From: Juan Baeza
Sent: 14 February 2018 14:00
To: Planning.Responses
Cc: Daniel Vick
Subject: WA/78/17/DOC

From: Paul Cann
Sent: 14 February 2018 13:34
To: Juan Baeza
Subject: RE: Oakview (formerly Red Cottage); Arun District Council Planning Application WA/34/17/PL (Granted) and WA/78/17/DOC (Reserved Matters)

Based upon recent correspondence, I can confirm that the drainage condition can be discharged.

Project: Red Cottage, West Sussex
Drawing No.: 536/501
Drawing Title: Typical Soakaway Section A-A
By: JD
Date: November 17

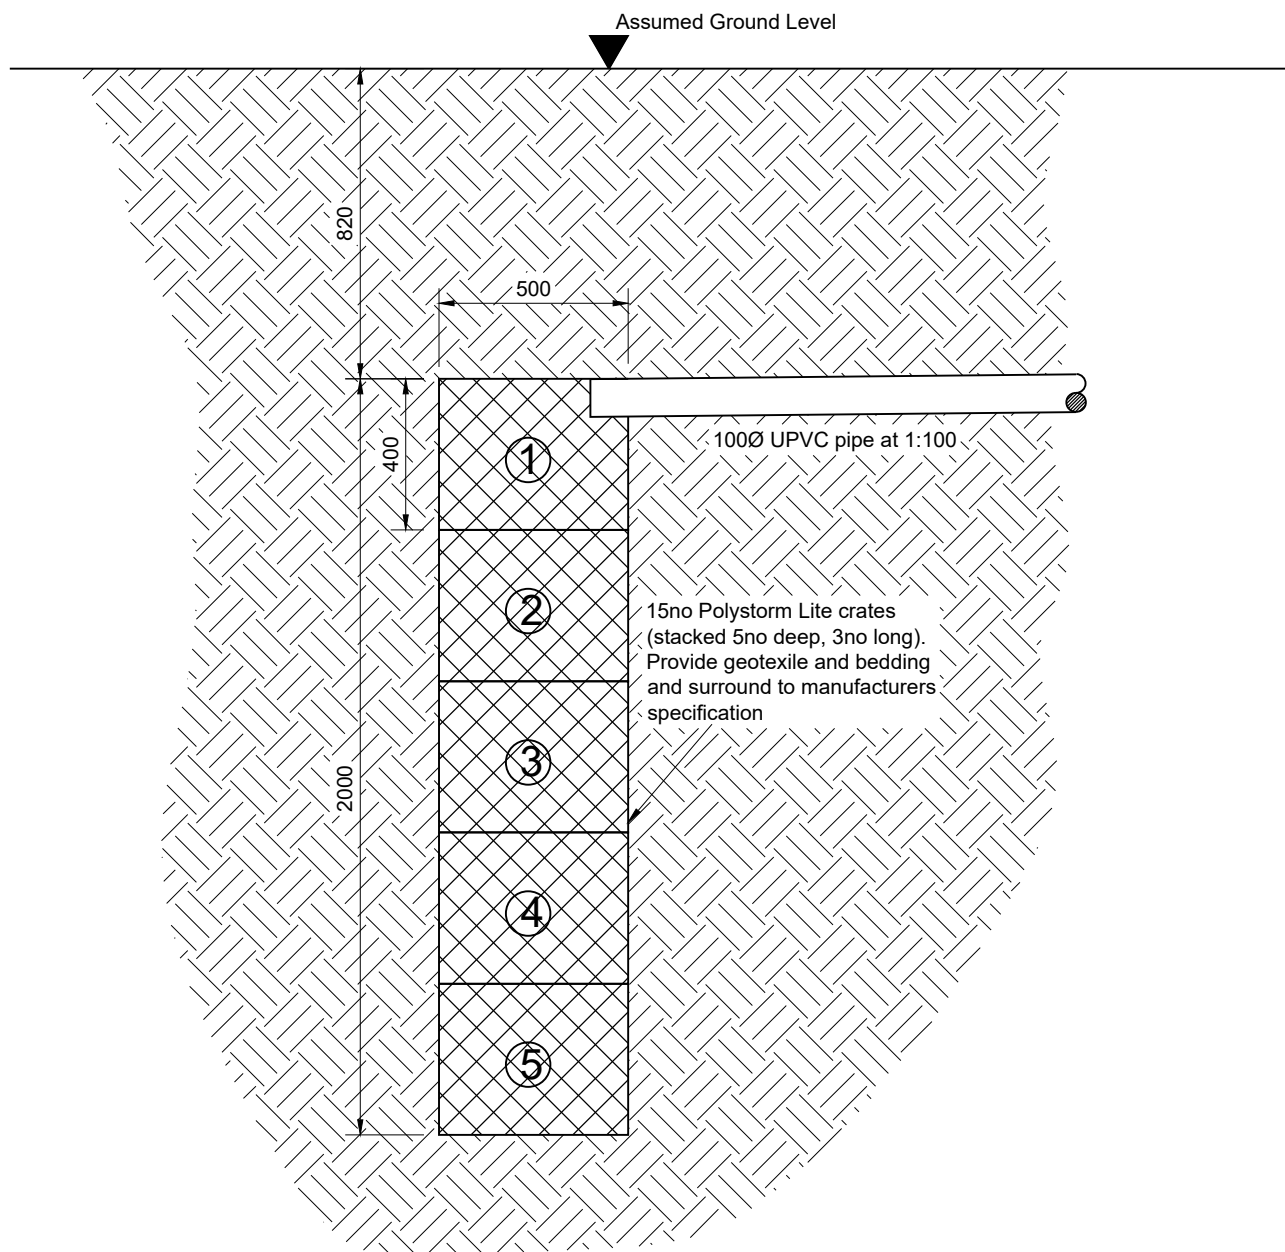
1. Please forward confirmation of the tree officers approval to the scheme when available.
2. Haworth McCall drawings – Please increase the internal diameter of the catchpit to 600mm. The cover slab should not be required for a chamber of this diameter as a 600mm cover should be fitted. Please adjust detail.

| Drawing No.:   | 536/500C                                              |

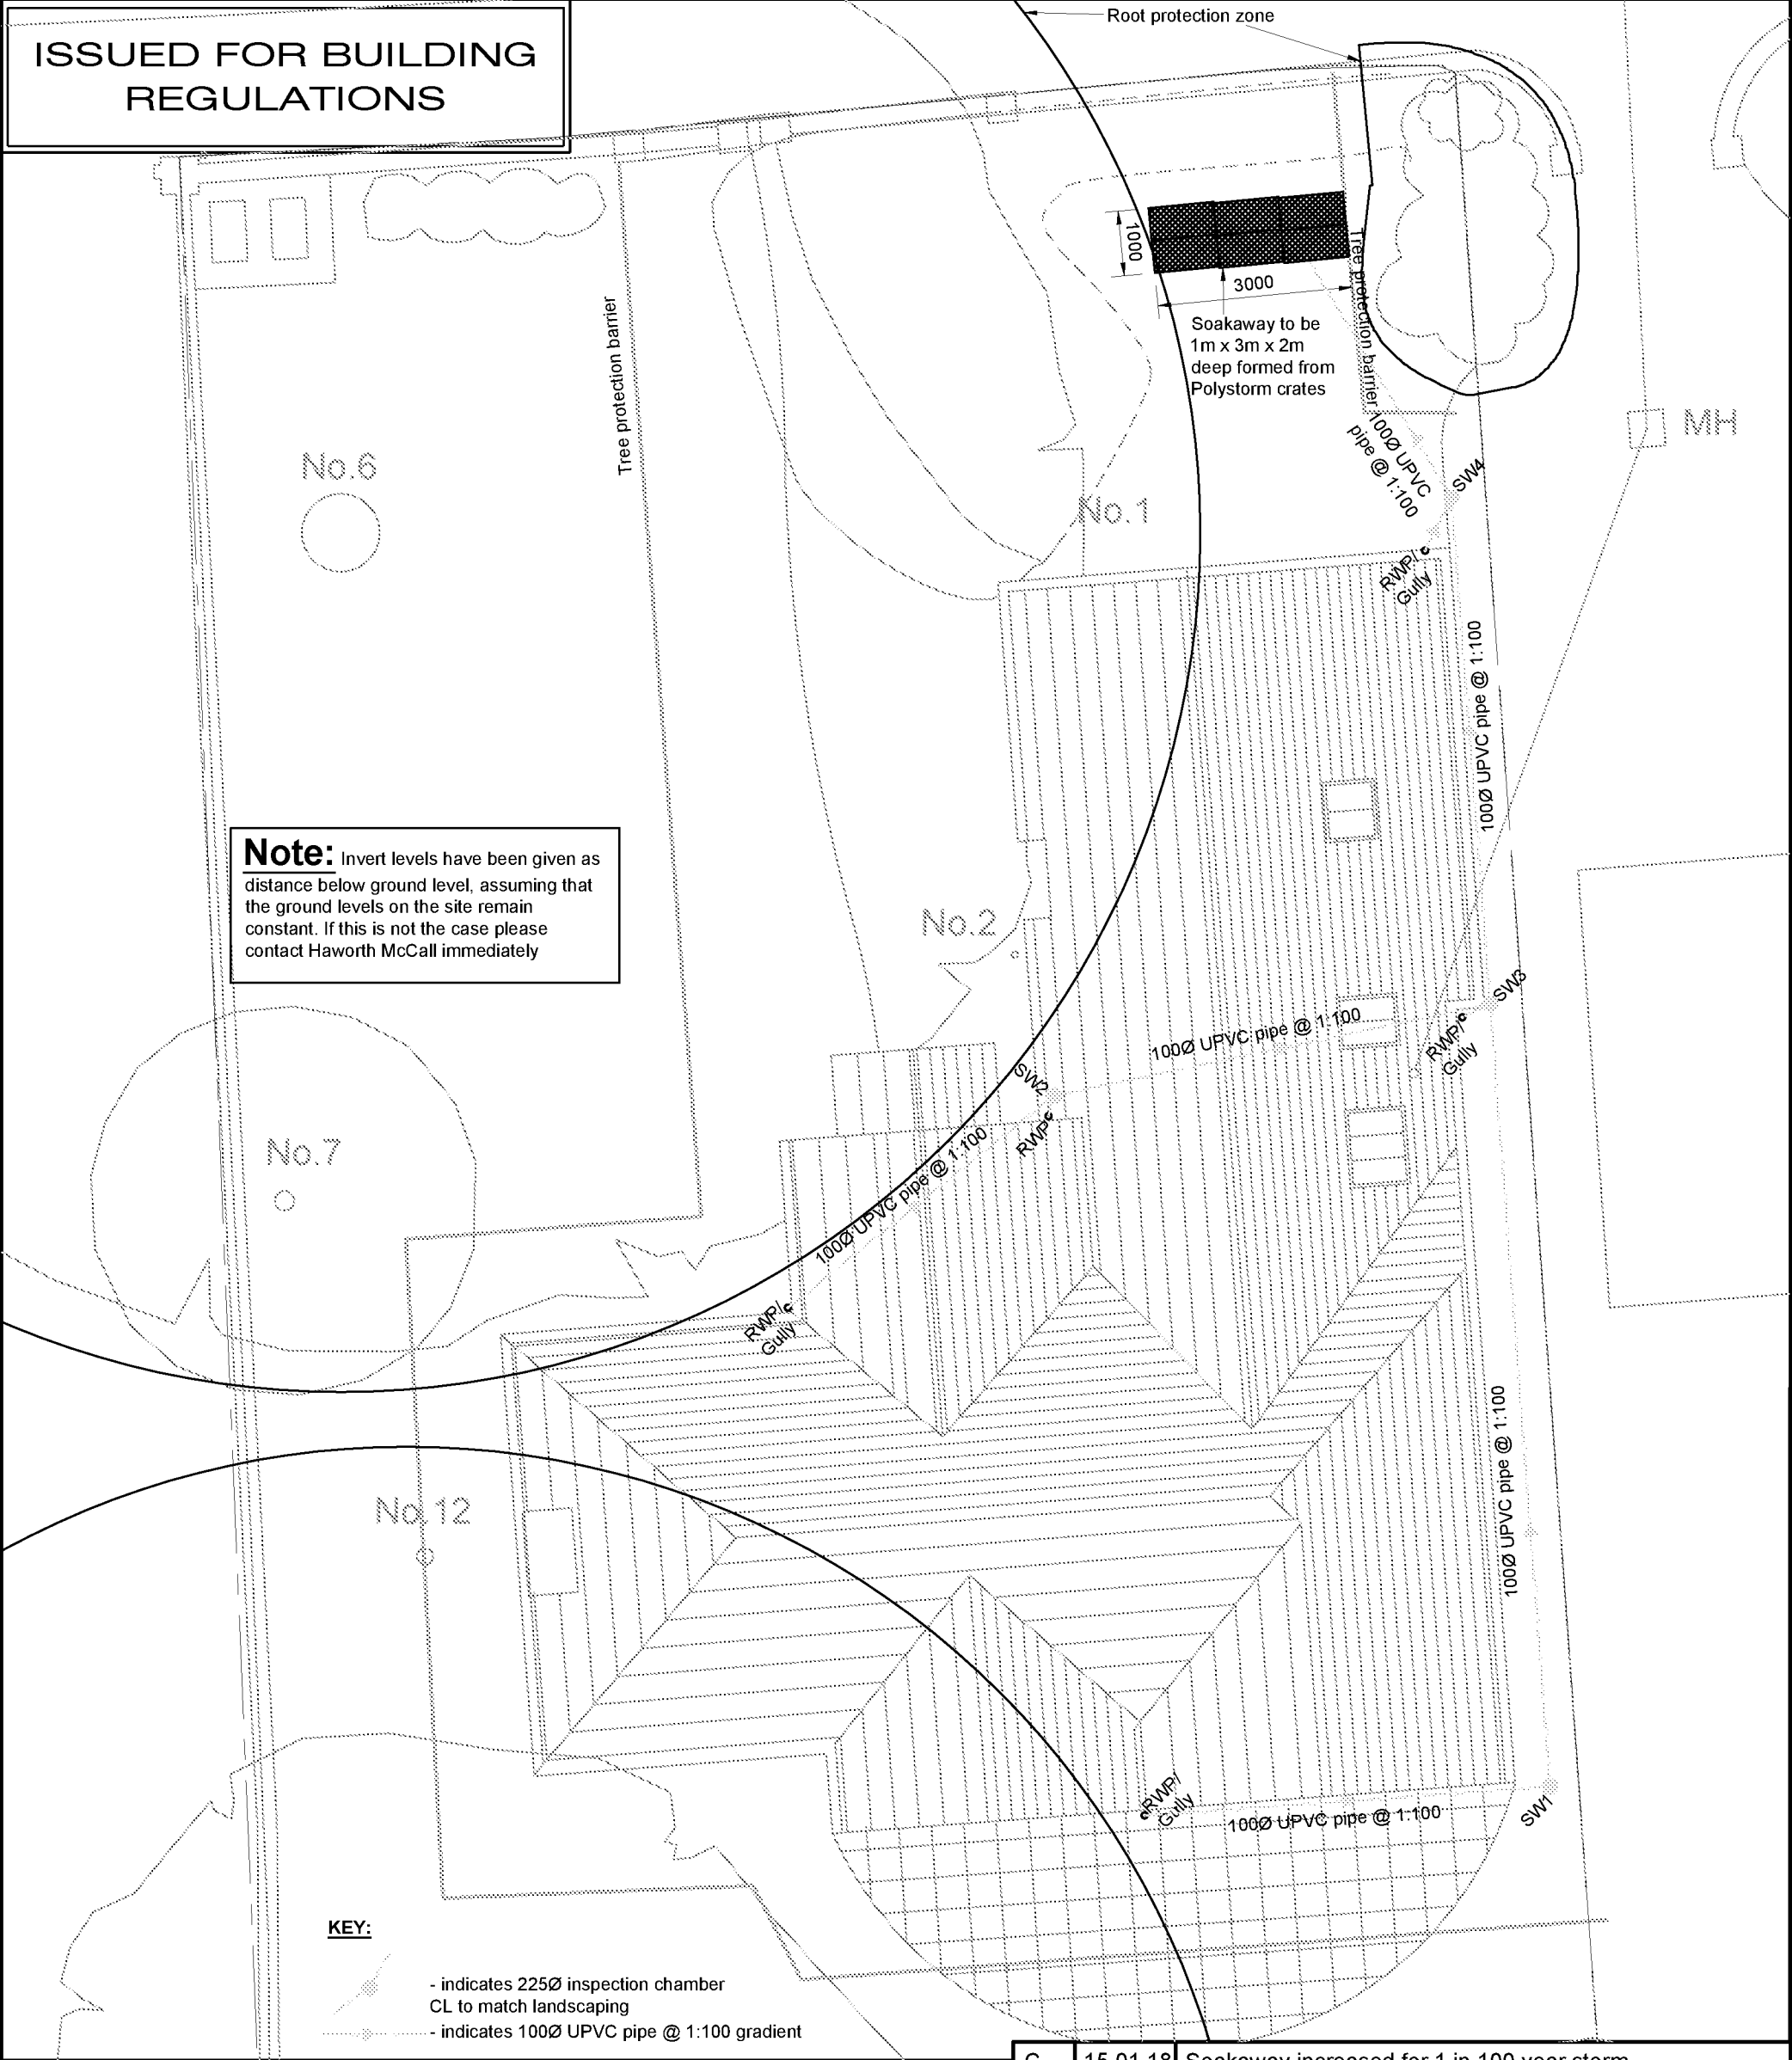
2. In order to prevent confusion, it is necessary to make it very clear that drawing no. C1036 P100 P1 is for the permeable pavement and must be read in conjunction with the Haworth McCall drawings. However, the McCall drawings needs amendment to suit, ie. remove the permeable pavement arrangements shown and make the modifications to the catch pit detail as per my email to Brendan Haworth dated the 24th January 2018, ie. specify 300mm deep sump. The cross section through the crate soakaway also needs to be updated to reflect the revised sizing. If it is easier, perhaps include all the drainage details on the CGS civils drawing? - Revised drawing attached from Haworth McCall which includes these changes. The building and external drainage has been separated.
